## **SSD 6010 – One Residential Building (Student Accommodation) within Darling Drive**

**Submission by:**

**Graeme Johnson**

**31 July 2013**

SHADOW DIAGRAMS: PERSPECTIVE, SHOWING THE PEAK, WINTER SOLSTICE

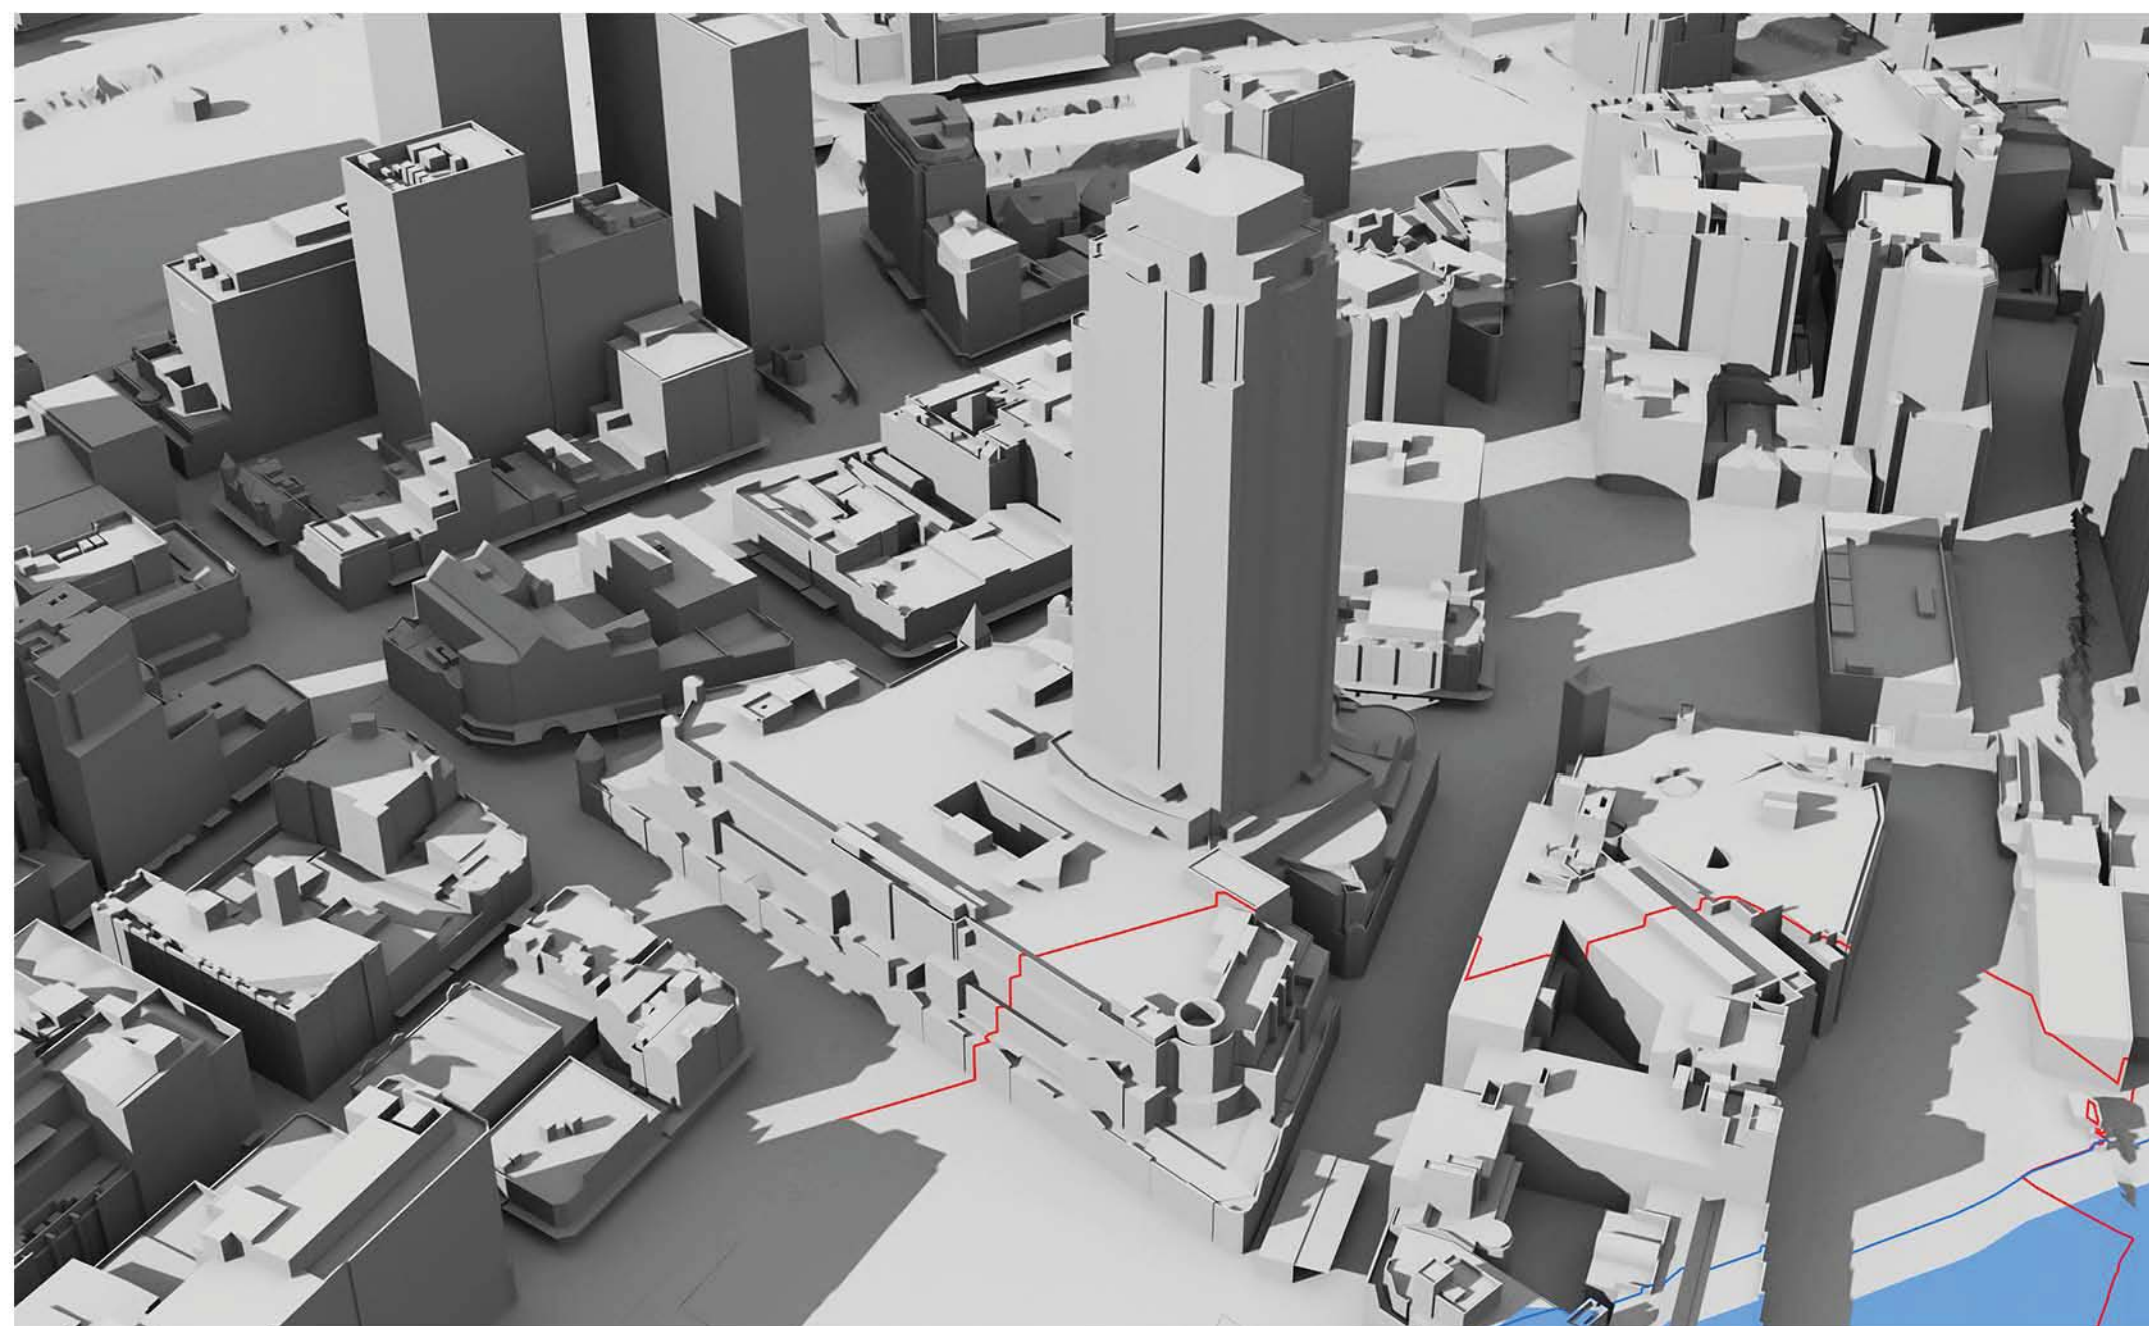
At 9am, 10am and 11am the west façade is totally in shadow due to other parts of The Peak building itself.

At 12pm there is still substantial existing shadowing on the west façade caused by the irregular shape of the west facade.

At 1pm the existing shadowing has been substantially removed, but not totally removed.

It can be concluded that some single aspect apartments on the west façade and some south-west dual aspect corner apartments currently receive less than 2 hours direct sunlight to habitable rooms and 50% of the private open space between 9am and 3pm on 21 June.

At 9am, 10am and 11am the west façade is totally in shadow due to other parts of The Peak building itself.

At 12pm there is still substantial existing shadowing on the west façade caused by the irregular shape of the west facade.

At 1pm the existing shadowing has been substantially, although not entirely, removed. However, overshadowing of lower levels of the west façade by the concept proposal parameter plan shadows for the N,NE and SE plots has already started.

By 2pm the existing shadowing has been totally removed. However, overshadowing of the west façade by the SSDA4 and SSDA5 buildings has appeared and risen further up the west façade than the concept proposal parameter plan shadows for the N,NE and SE plots, which is still present.

At 3pm, the proponent states correctly that 45-45% of the western façade is overshadowed by the SSDA4 and SSDA5 buildings.

It can be concluded that, as a result of combination of the proposed development with existing shadowing of the west façade, some single aspect apartments on the west façade and the south-west dual aspect corner apartments which currently receive less than 2 hours direct sunlight to habitable rooms and 50% of the private open space between 9am and 3pm on 21 June will suffer additional overshadowing. It is beyond our skills to count the number of such apartments. We note that the proponent has made no attempt to do so.
